Written Representation to the Examining Authority (ExA) regarding the Environmental Statement submitted by Tritax Symmetry (Hinckley) Ltd in respect of their proposed Hinckley National Rail Freight Interchange and with particular reference to Chapter 10: Noise and vibration

This Written Representation is with particular reference to Chapter 10: Noise and vibration, reference: 6.1.10, revision 07 [APP-119] and its associated documents.

00:00 on 25/04/2021 to 00:00 on 26/04/2021

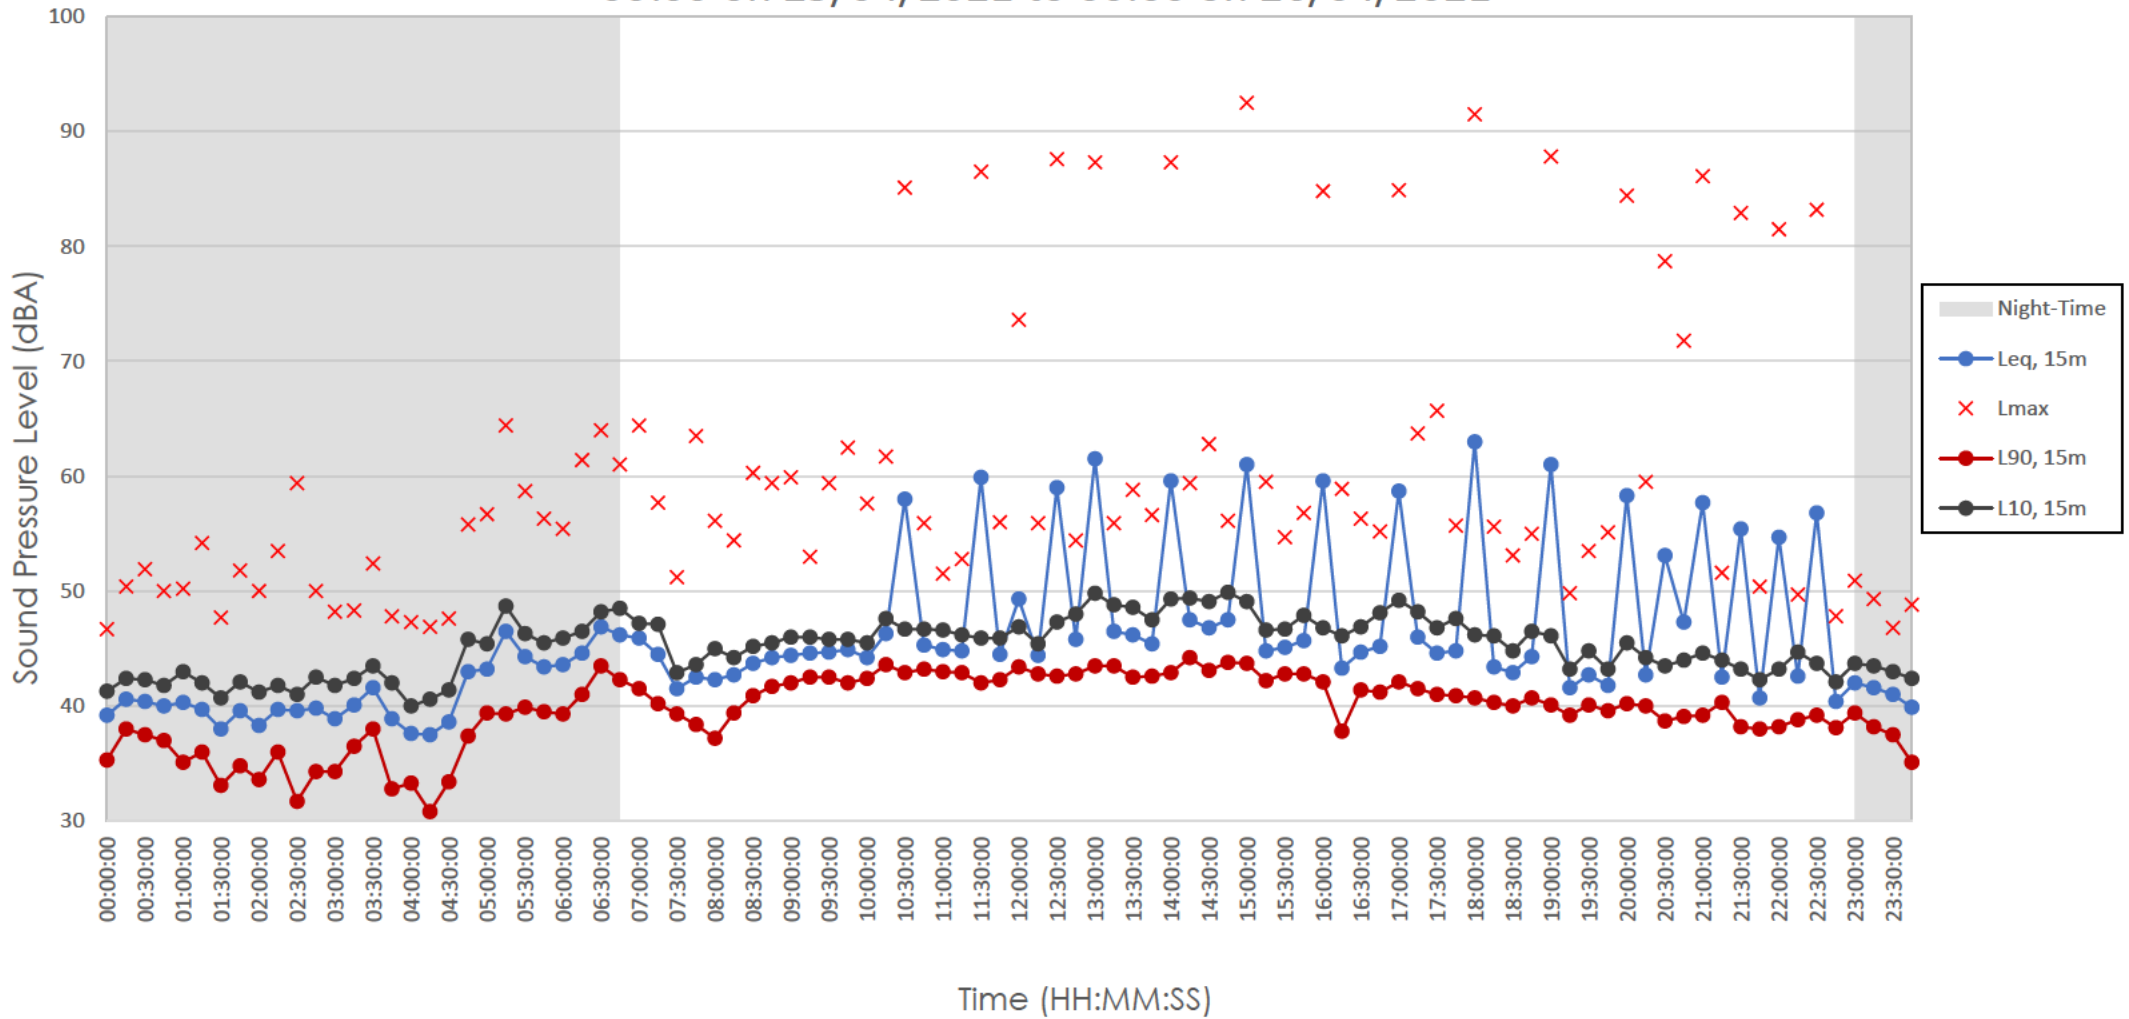
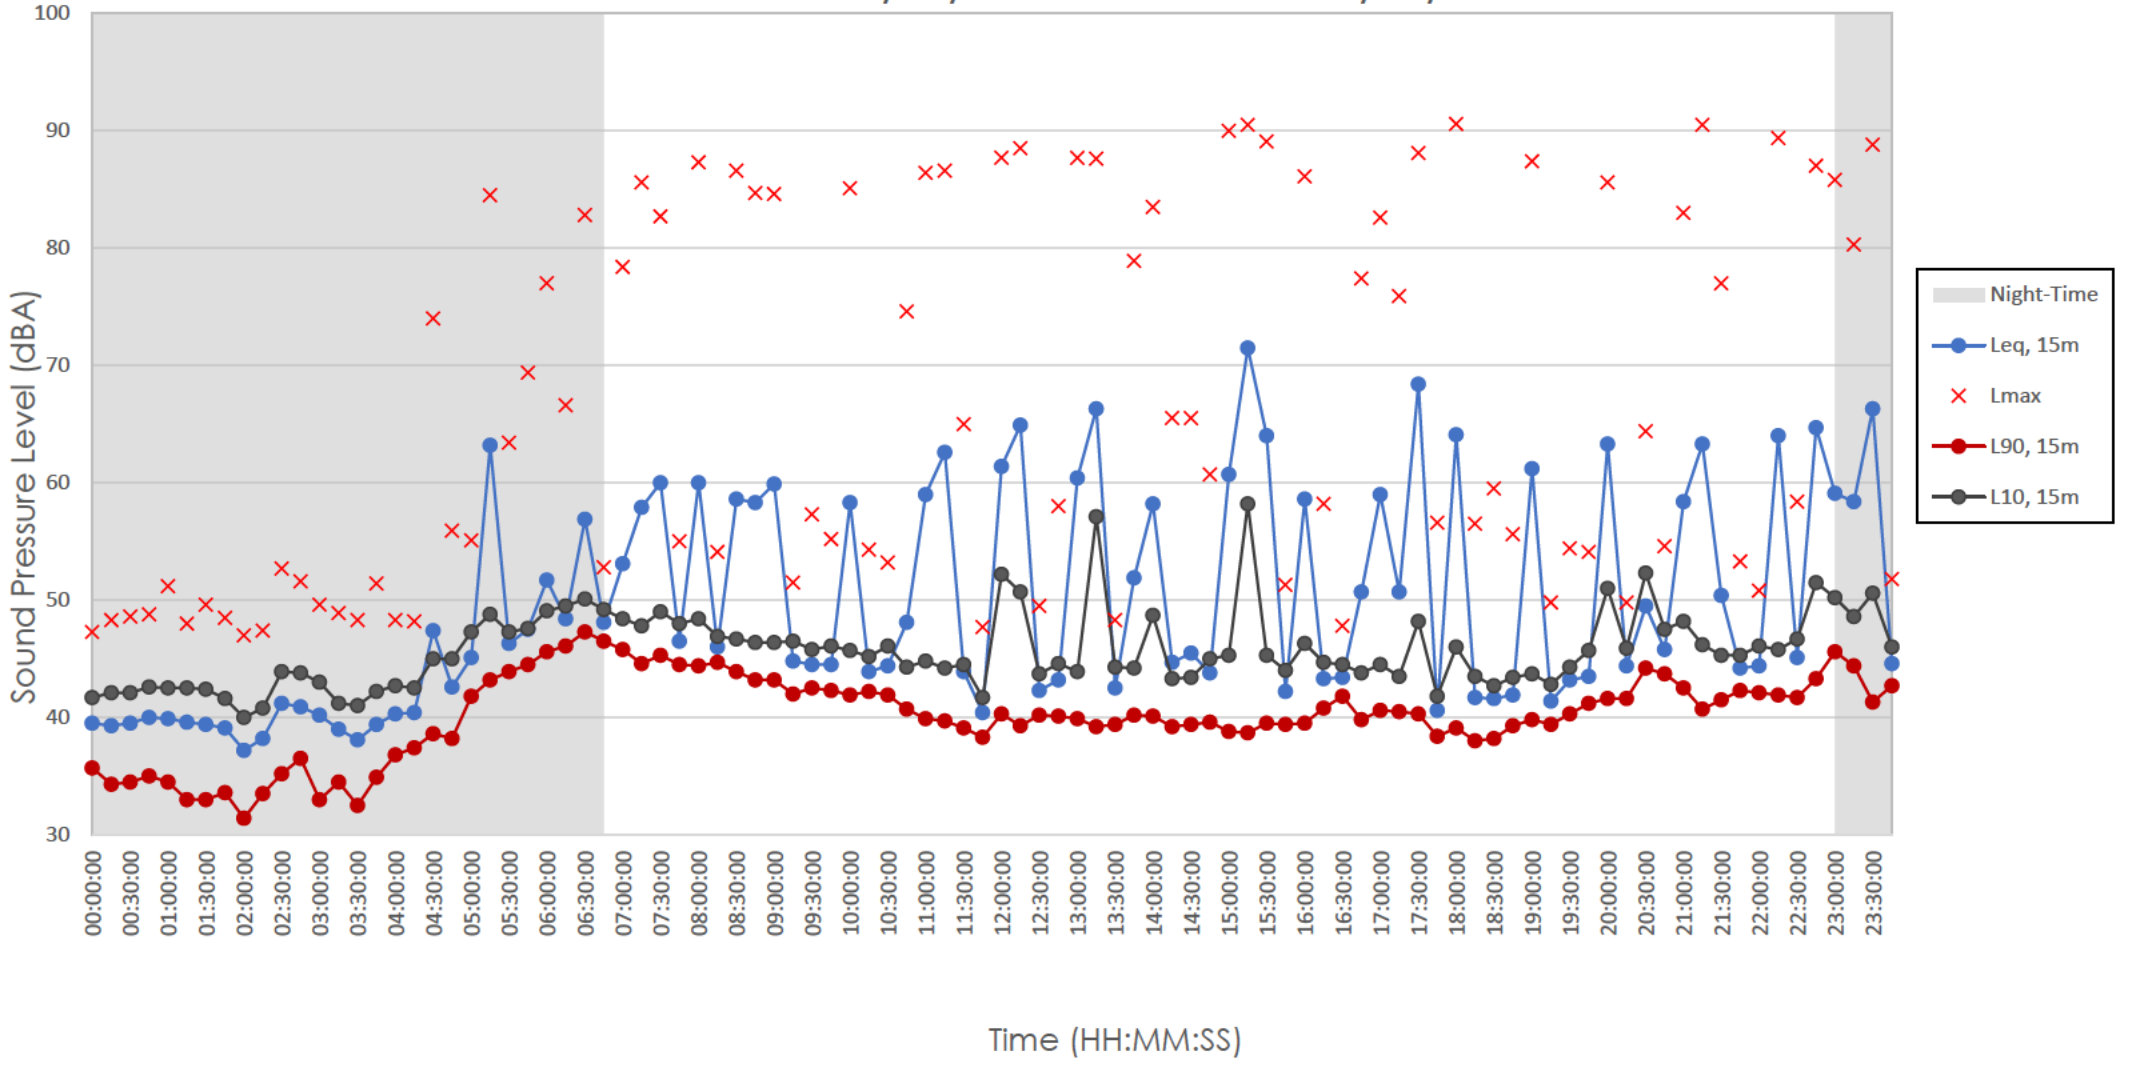
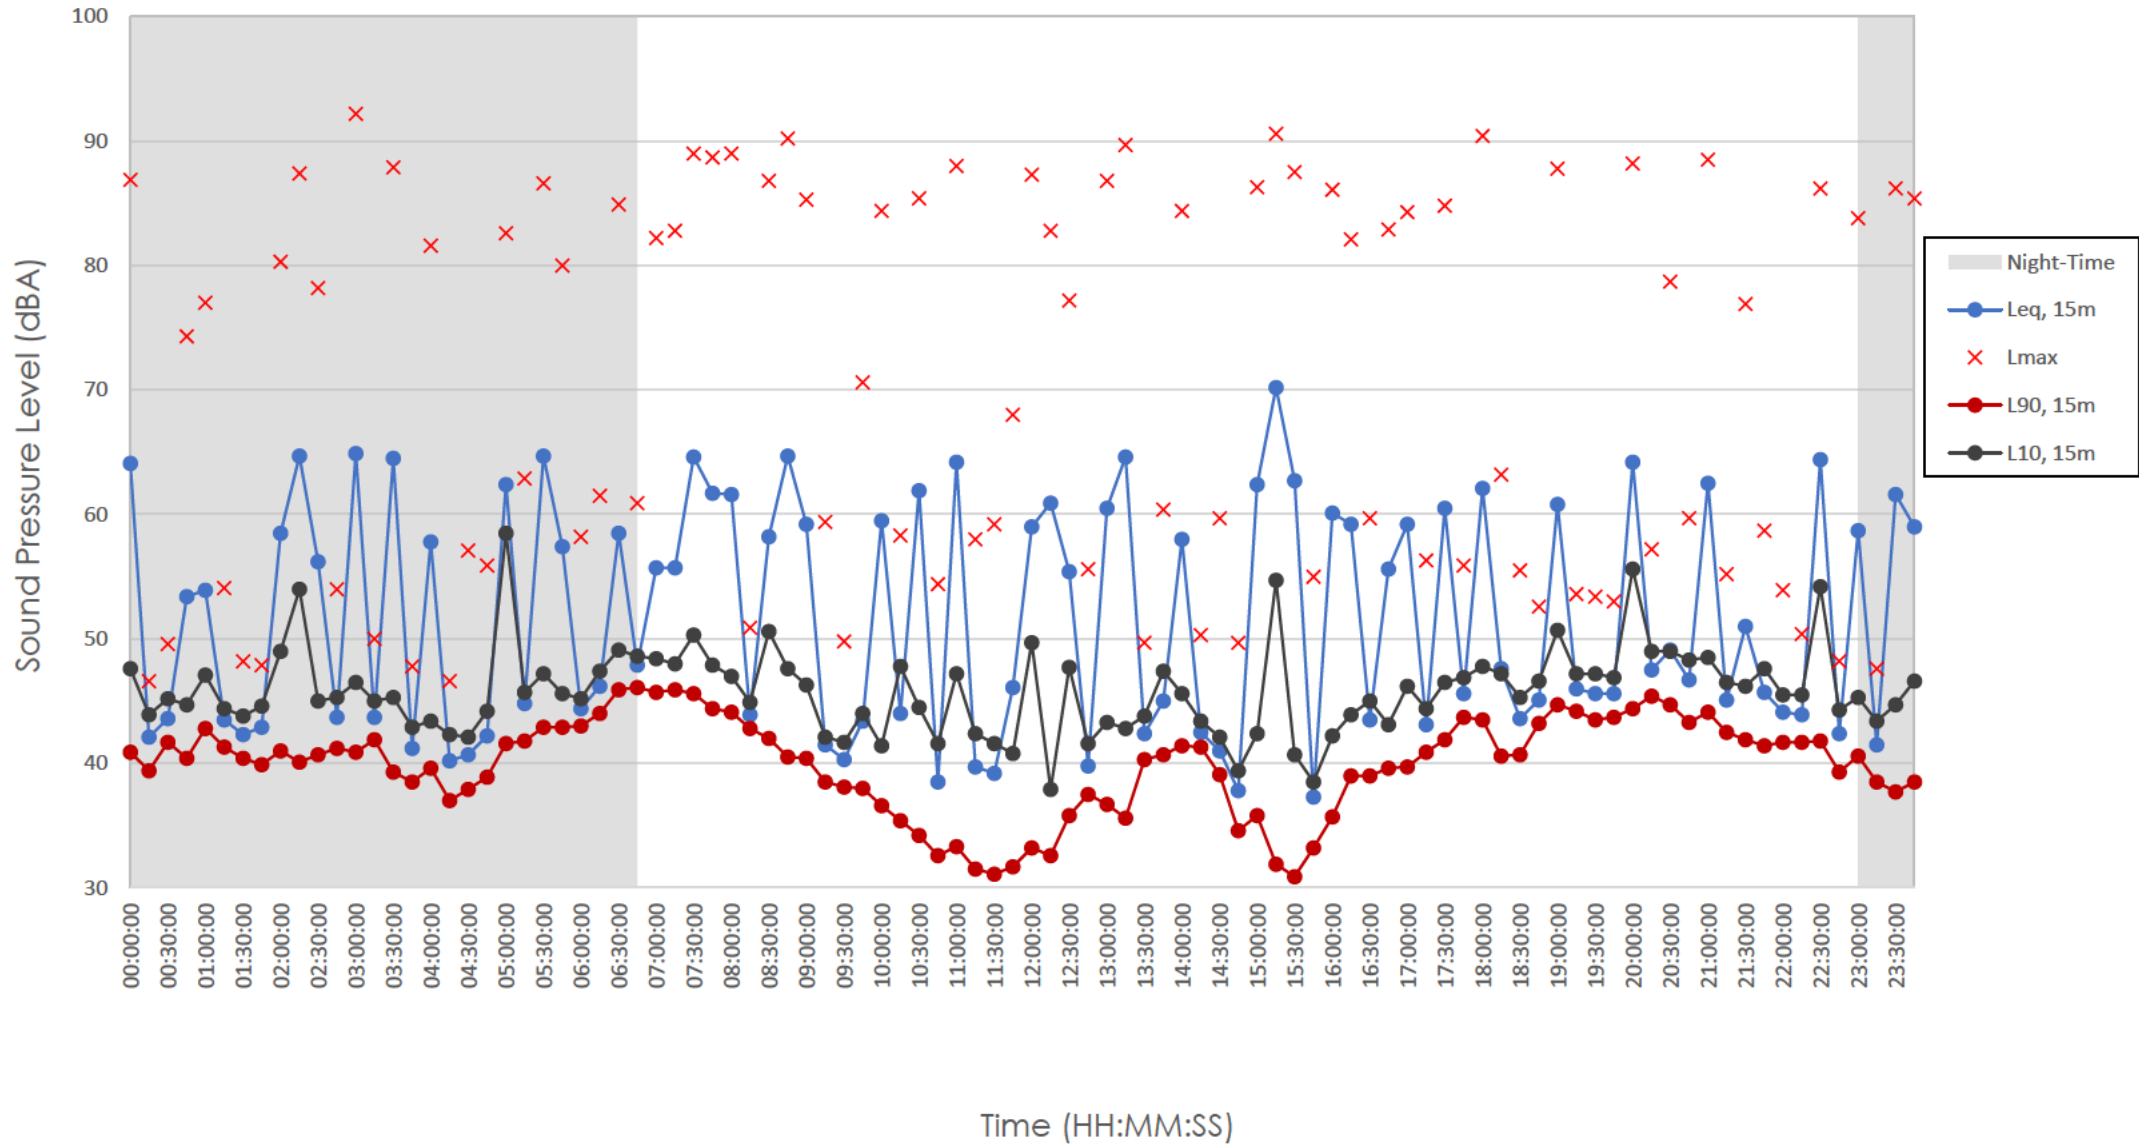
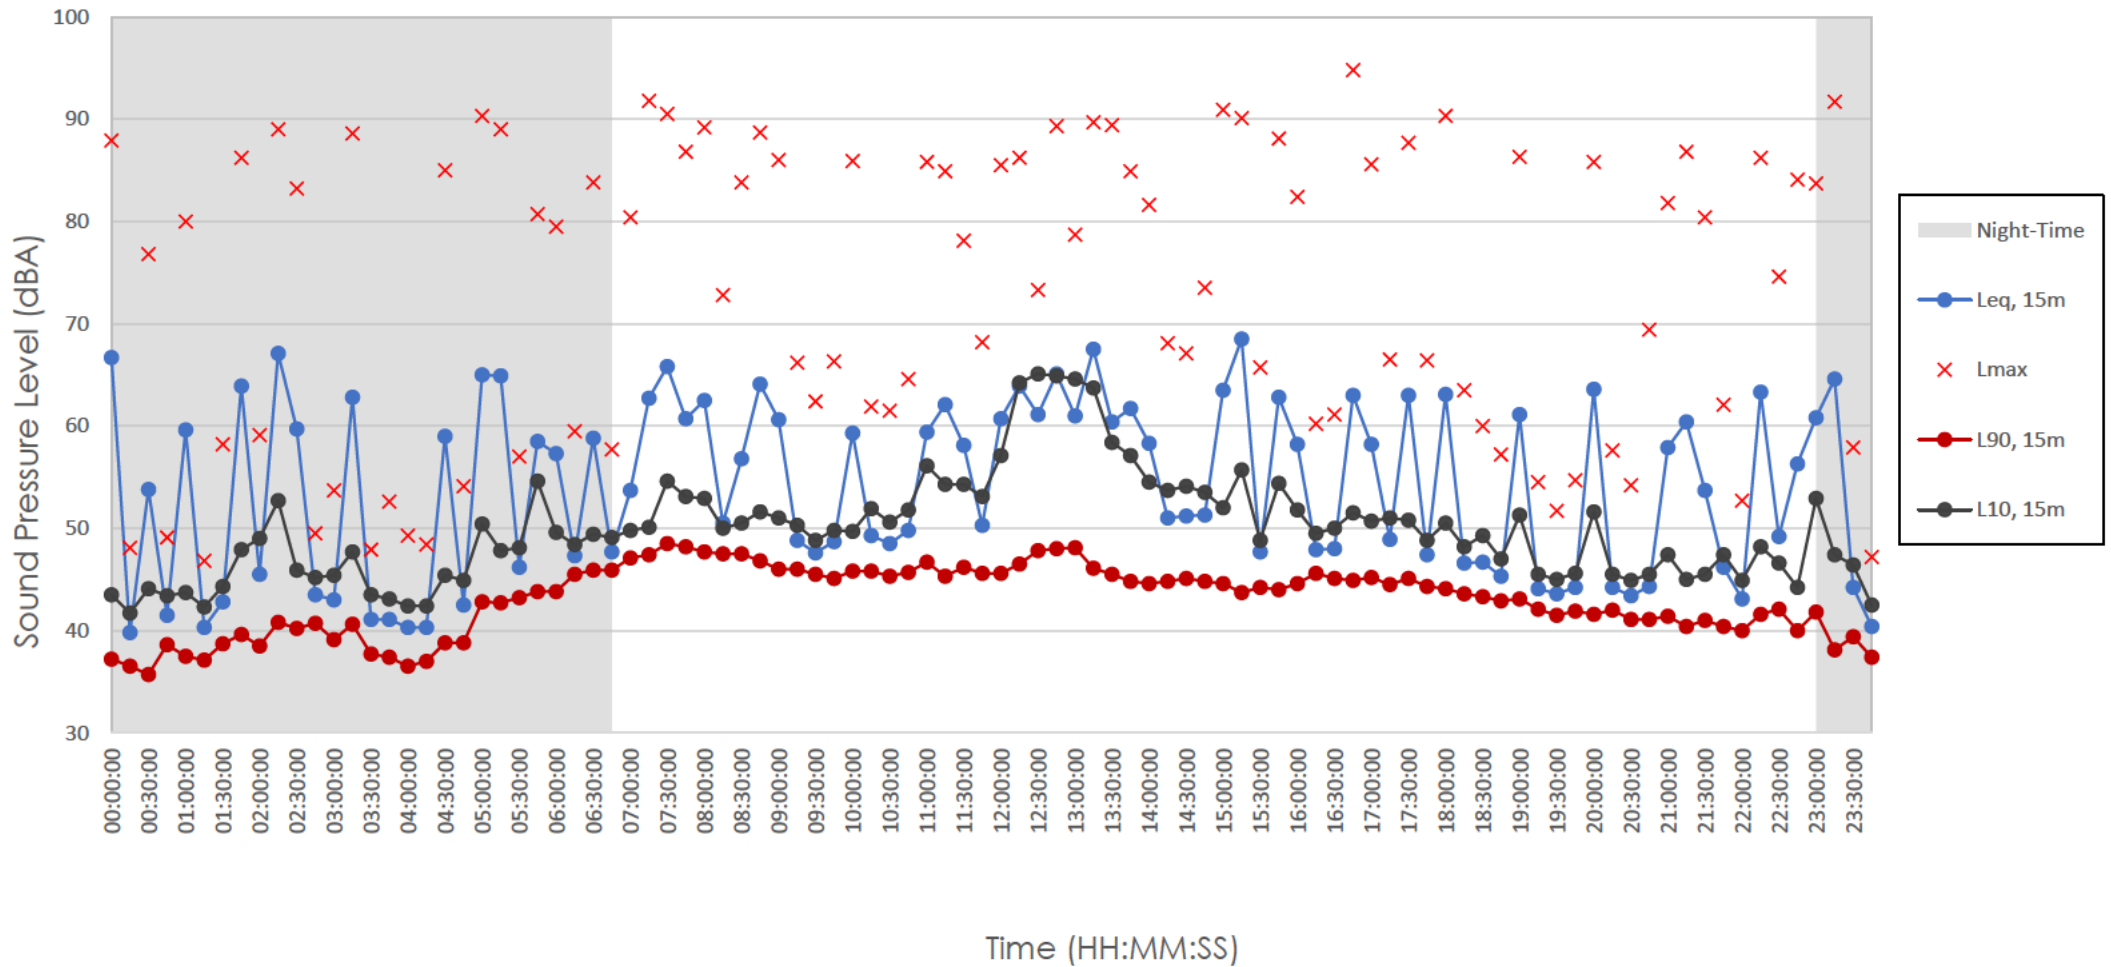
This means, for example, that the sound levels L_{Aeq} measured at noise monitoring position NMP4 have been taken and directly imposed upon all of the Noise Sensitive Receptors NSR1, NSR2, NSR3, NSR4, NSR5, NSR6, NSR7, NSR8, NSR24, NSR25 and NSR26.

This is wrong, and is a flagrant, fundamental and extremely grave failing in Tritax’s Noise and vibration report.

Because in conditions where the Ambient sound is strongly dependent upon a Specific Sound Source, both the Specific Sound and the Ambient Sound are strongly dependent upon the distance from that Specific Sound Source.

Were it not for the fact that this appears in an Environmental Study for a Strategic Rail Freight Interchange, Tritax’s approach here would be slightly comic. Because it means, for example, that Tritax believe that each one of the eleven NSRs mentioned above all actually experience the same ambient sound level, L_{Aeq} , as the Noise Monitoring Position NMP4 that Tritax placed close by the side of the railway track! Even though some of those NSRs are located in excess of 400 metres away from the railway track!
